**CITY OF ALBUQUERQUE
PLANNING DEPARTMENT
September 9, 2015
DRB Comments**

PROJECT # 1010587

APPLICATION # 15-70311

RE: Lots 1 - 12, Blocks 6 & 7, Northern Addition

PLAT OF
LOTS 1A, 2A & 3A
NORTHERN ADDITION
 BEING A REPLAT OF LOTS 1 THRU 12
 BLOCKS 6 & 7 NORTHERN ADDITION
 SECTION 17, T. 10 N., R. 3 E., N.M.P.M..
 CITY OF ALBUQUERQUE, BERNALILLO COUNTY, NEW MEXICO
 JULY, 2015

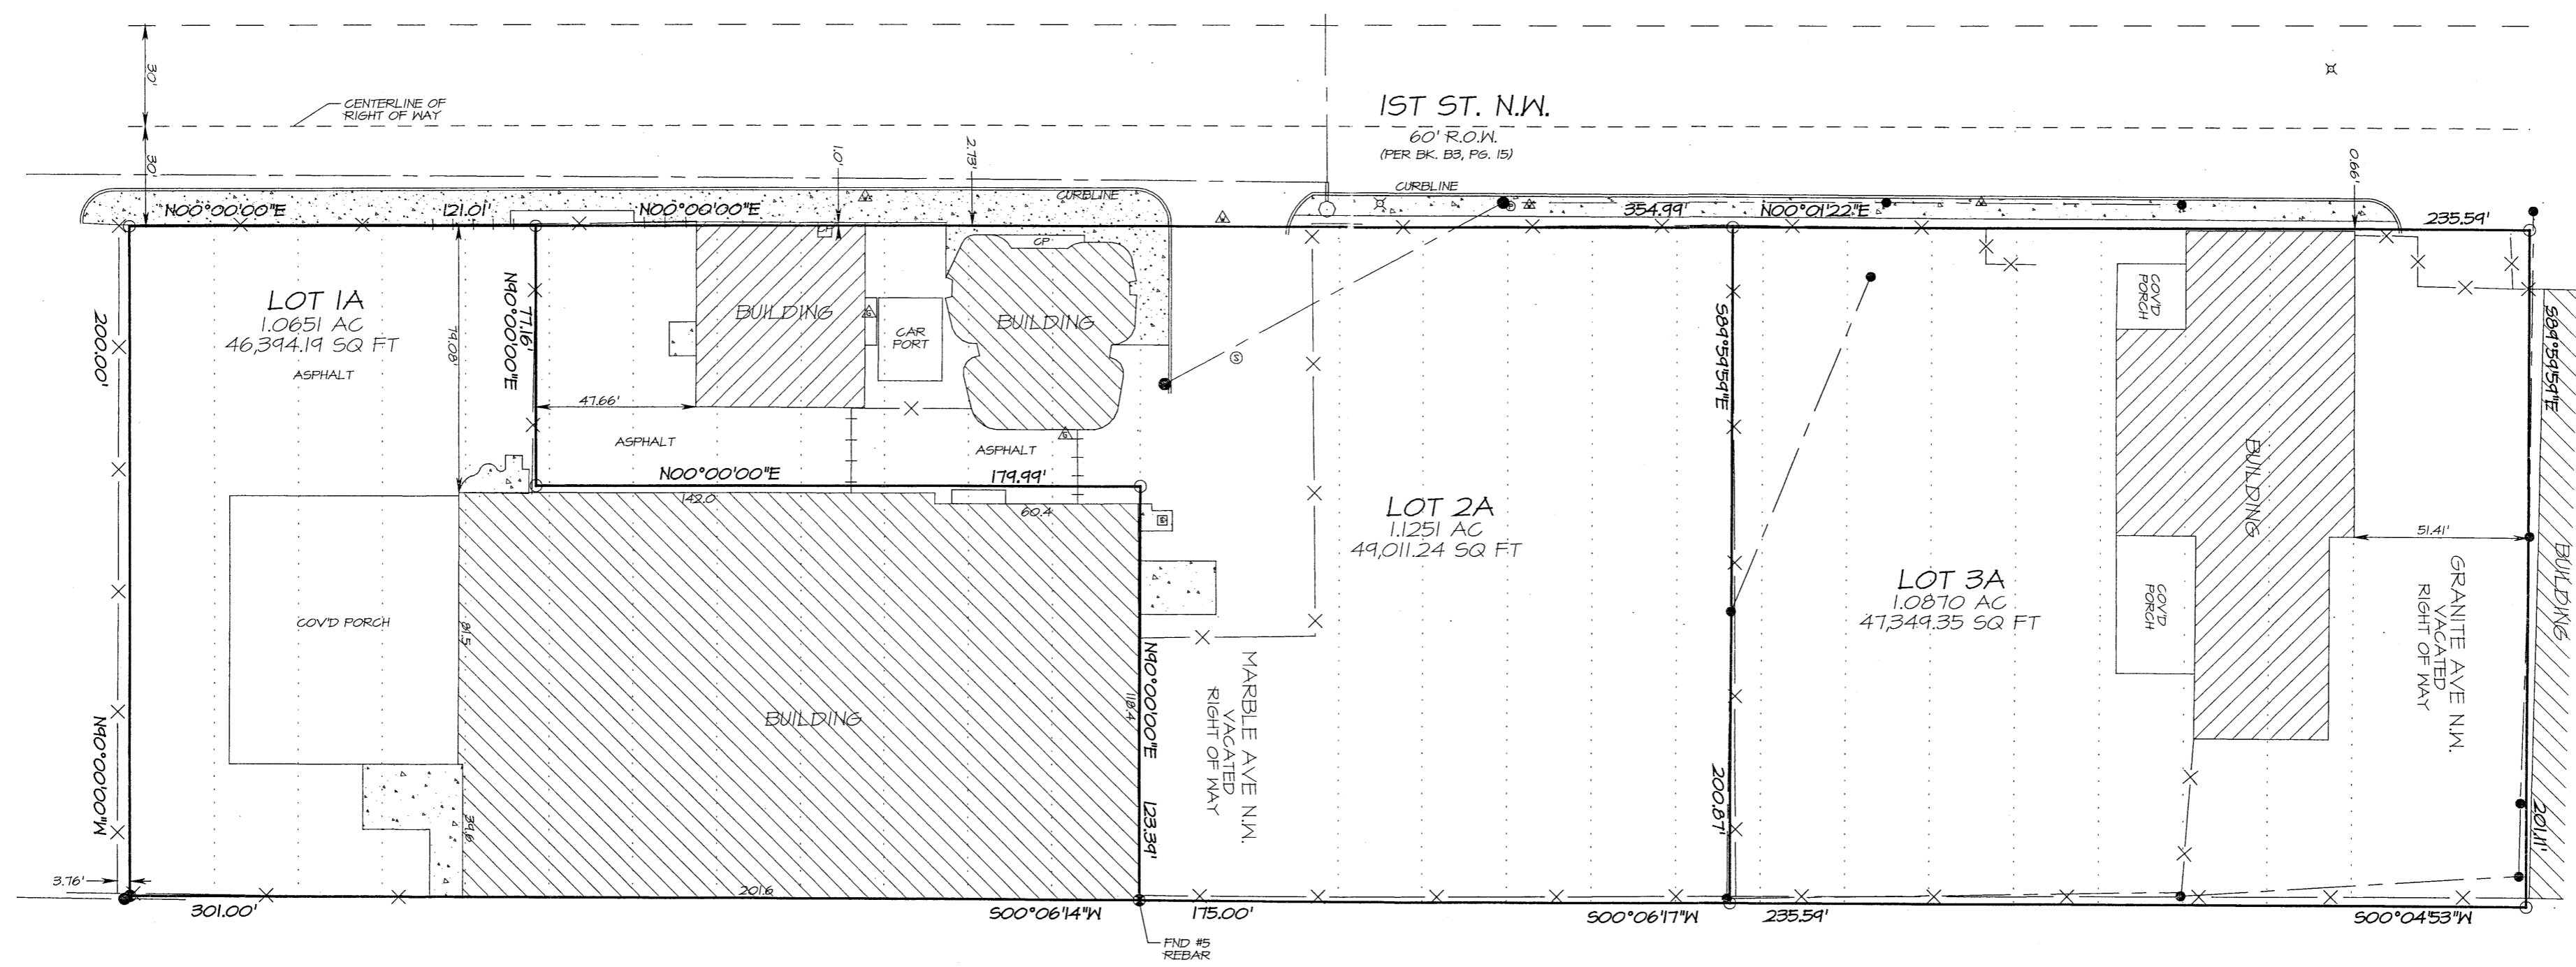
The Location Map needs to identify the site. The plat title, purpose, and legal description need to identify the vacated rights of way, and the Real Property Division will need to review and sign the plat. Parking layout and calculations are needed to demonstrate that On-site Parking Regulations will be complied with on new lots. Compliance with Building Code for zero lot line on proposed 1A will need to be verified in writing by a licensed architect or engineer.
